## Engineers Comments Regarding Surface Water Drainage

| <b>Application Reference:</b>   | BE/141/25/DOC                                                                                                                 | <b>Reviewer Reference:</b> | ADC/EXT4b  |
| <b>Site Name:</b>               | Land at Oldlands Farm Newlands Road Bognor Regis PO22 9NN                                                                     |                            |            |
| <b>Application Description:</b> | Approval of details reserved by condition imposed under BE/150/22/OUT relating to condition 22-surface water drainage scheme. |                            |            |

243912-BWB-EXT-XX-G-C-0539-[S2-P03]_Drainage Flood Volumes 100yr + 45%
Climate Change Exceedance Plan

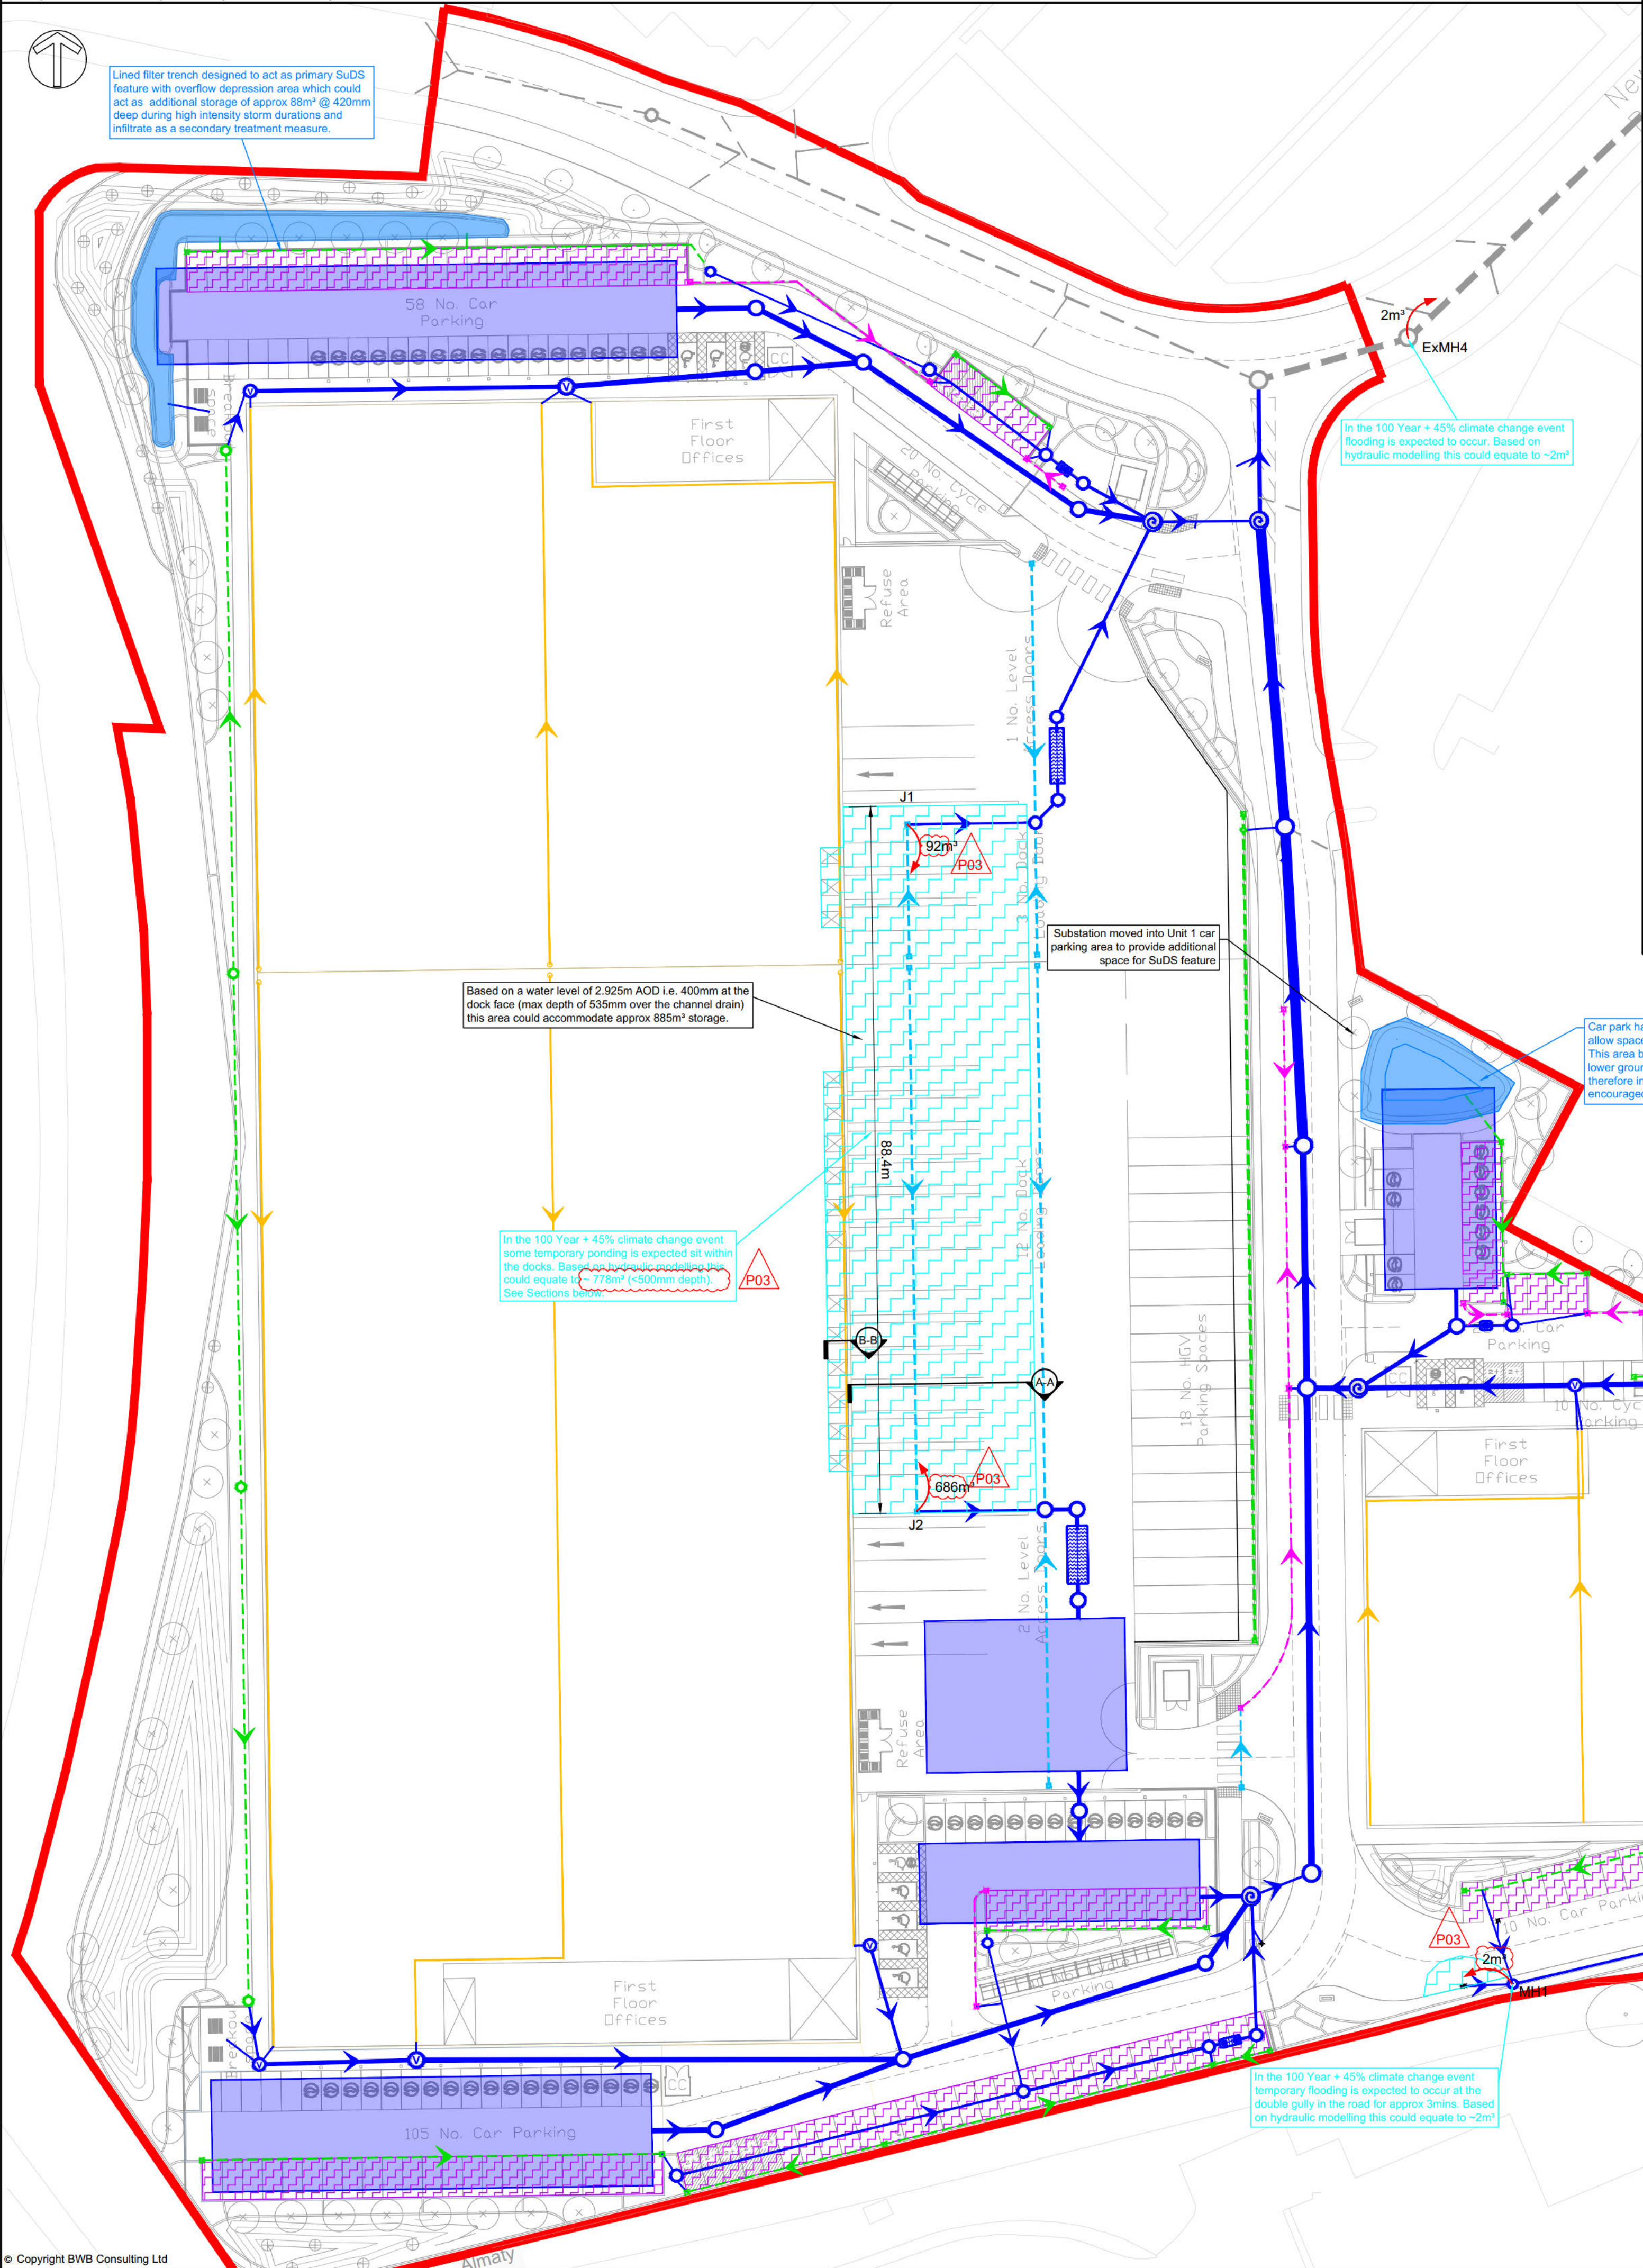
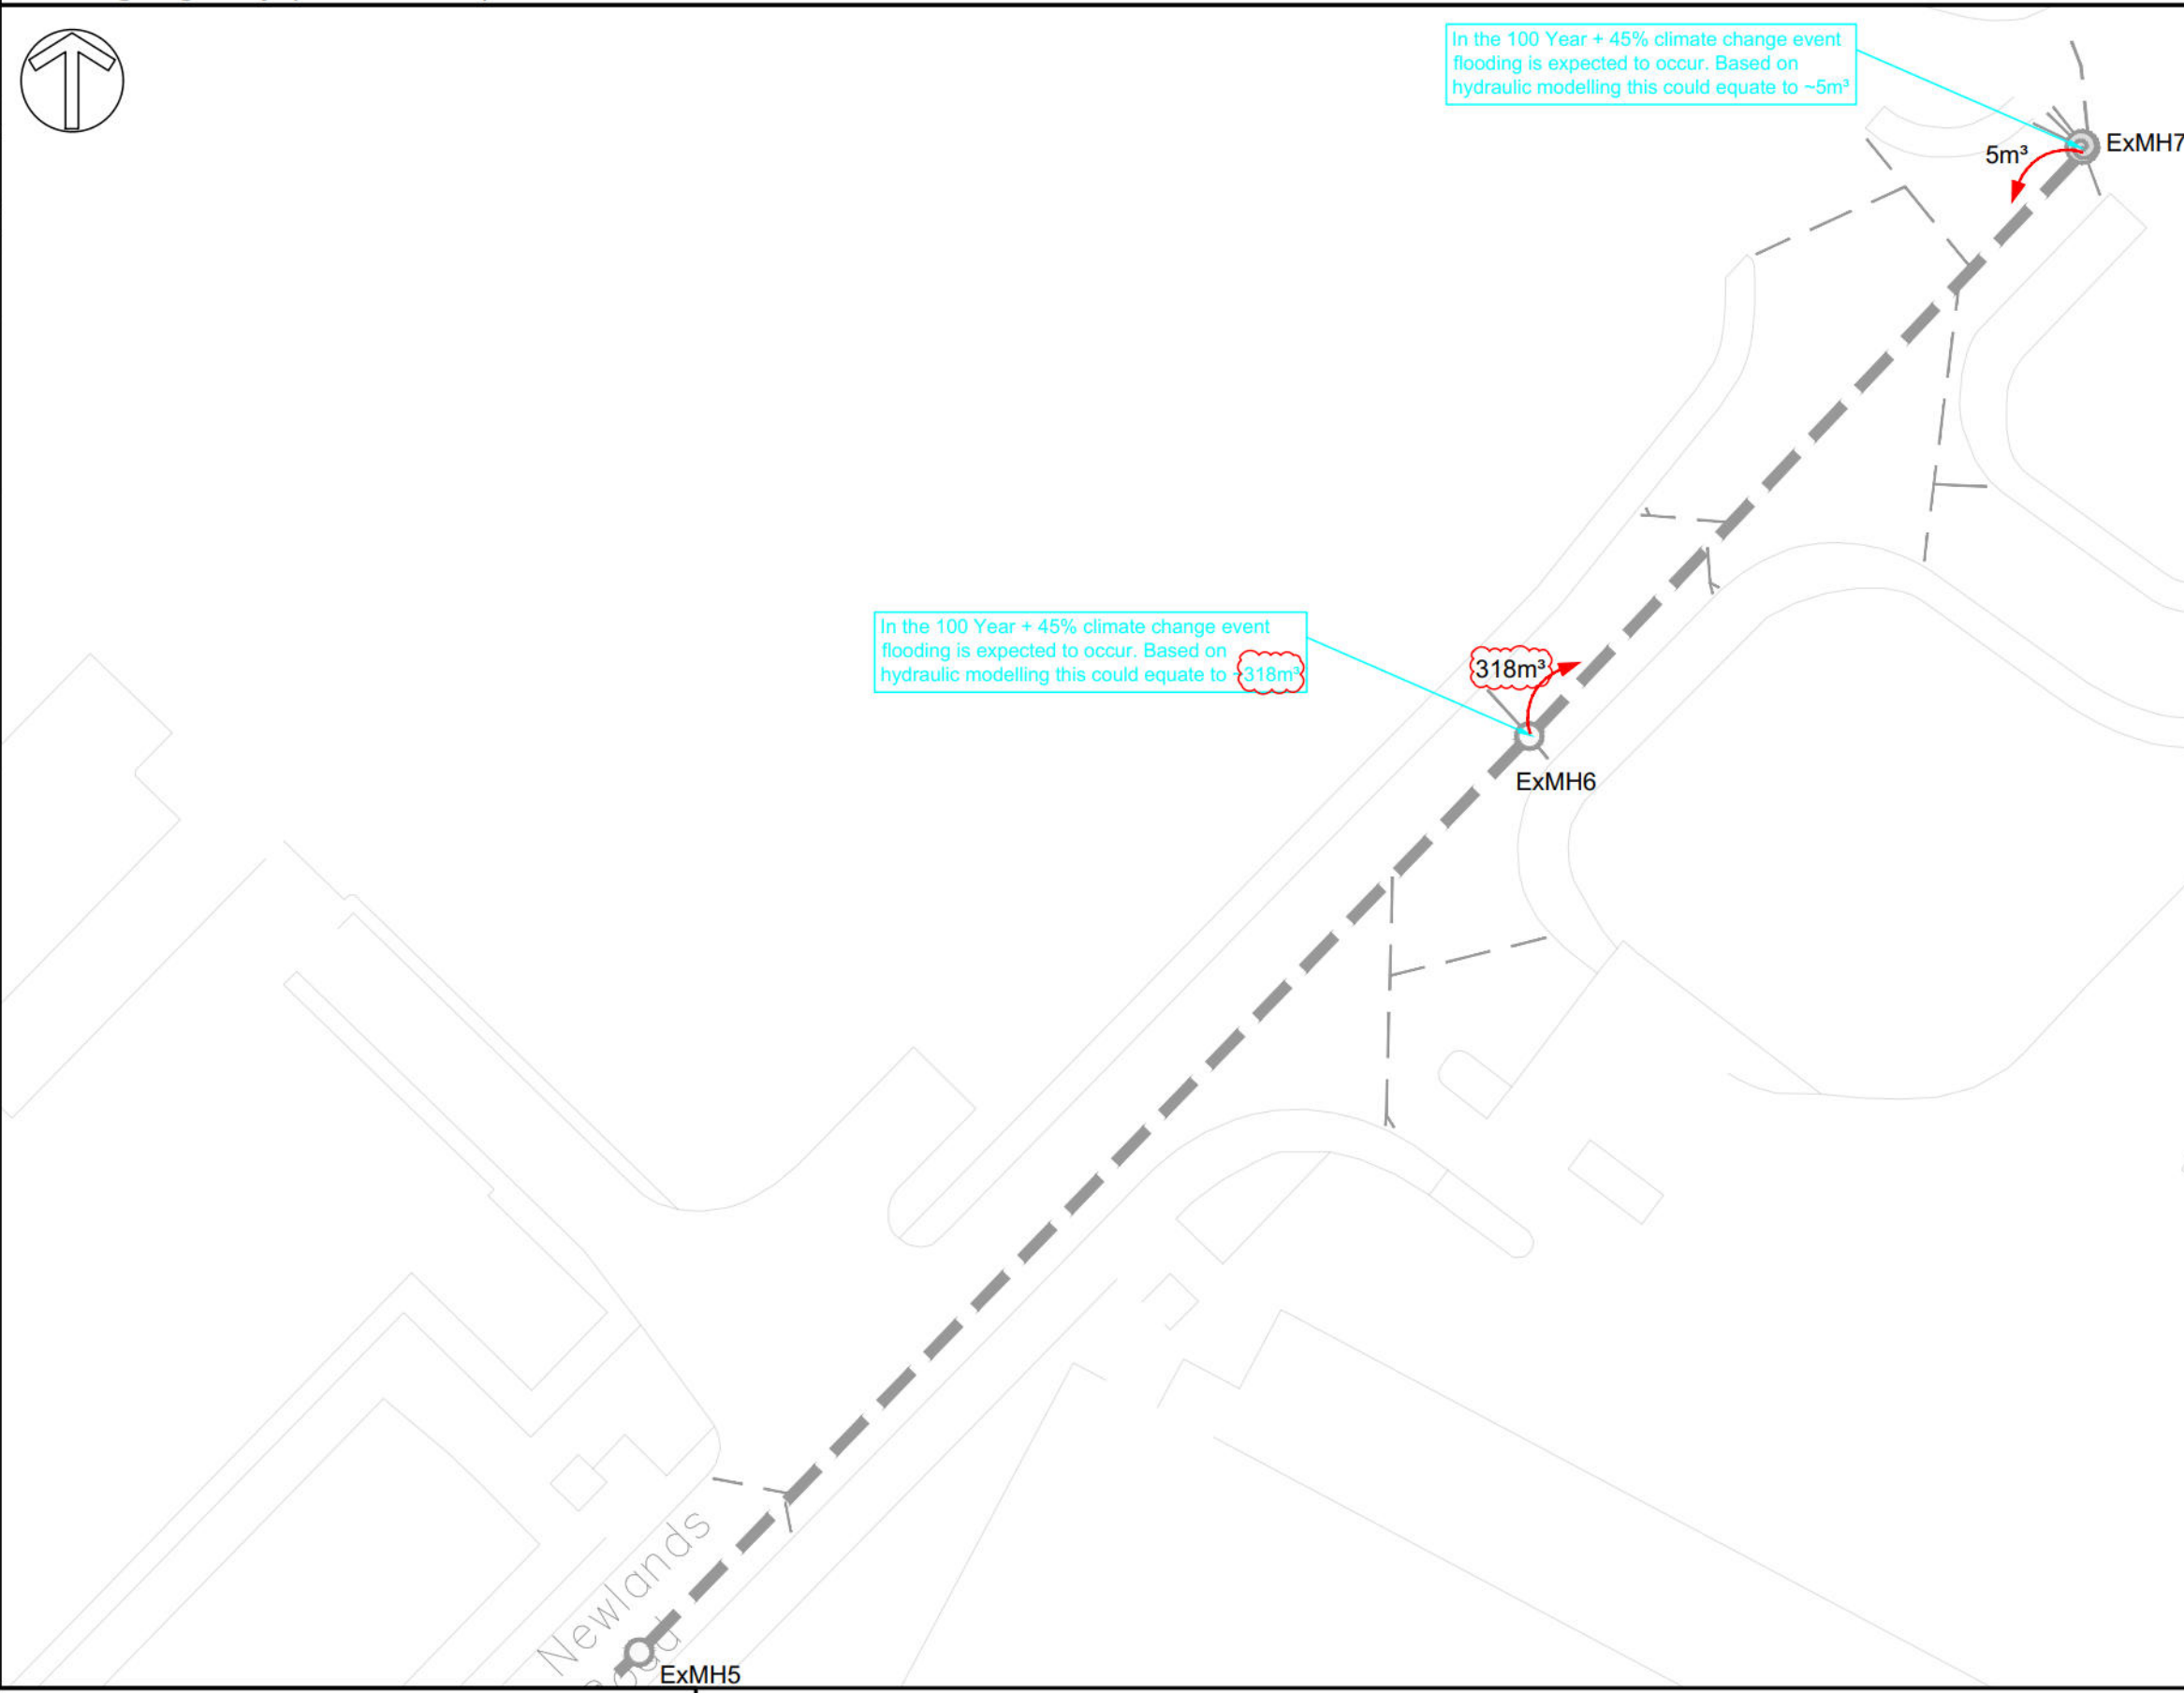
| 13. | <p>The temporary flooding of the loading docks for the 1% AEP +CCA event may be acceptable. However, the risk and impact of the proposed flooding has not been adequately assessed.</p>        | <p>The flooding of the docks is a well understood and acceptable way to deal with extreme flood events. The docks by their very purpose are naturally lower than the surrounding areas (i.e. 1.2m below FFL). To ensure they are adequately drained there is a channel drain approx. 8m from the building face. This is the lowest point of the drainage system so inevitably is the first area for water to back up in extreme events. Water will back up vertically from the channel at this low point, so there is no/minimal velocity involved.</p> <p>Panattoni is a major developer of industrial and distribution units delivering buildings for logistics operators all over Europe. They, better than anyone, understand the operation of a loading dock required by their customers. In this area of the site, vehicles reverse into the dock and are rear loaded from level access doors that are set at floor level, consistent with the level of the trailer bed. There is no side loading in the docks, this takes place at a higher elevation through the level access doors. There is no regular requirement for foot traffic or anything other than high wheelbase HGVs to access the area of the docks. As such, the operation of the loading docks is uninhibited by flooding in the extreme event.</p> <p>The Panattoni development specification accepts flooding of the loading docks in all events greater than the current 3.33% AEP to be 'designed in' to the system. This provides a balance of issues, including the drainage system functionality, the visual impact issues influenced by the finished floor level, sustainability and carbon impacts caused by excessive fill imports and</p> |  |  |  |

| 15. | It has not been demonstrated that the temporary flooding within highways following development will be shallow, slow flowing and represent a low hazard. | The flooding of the existing highway is an existing situation resulting from the increase in rainfall statistics between the date of design and today. The manhole that is shown to flood is in close proximity to the watercourse. It has been shown that runoff from this flood would direct overland a short distance to the existing watercourse.                                                                                                                                                                                                                                                                                                                                                                                                                                                                                                                                                                                                                                                                                                                                                                                                                                                                                                                                                                                                                                                                                                                                                                                                                                                                                                                                                                                                                                                                                                                                                                                                                                                                                                                                                                           |  |  |  |
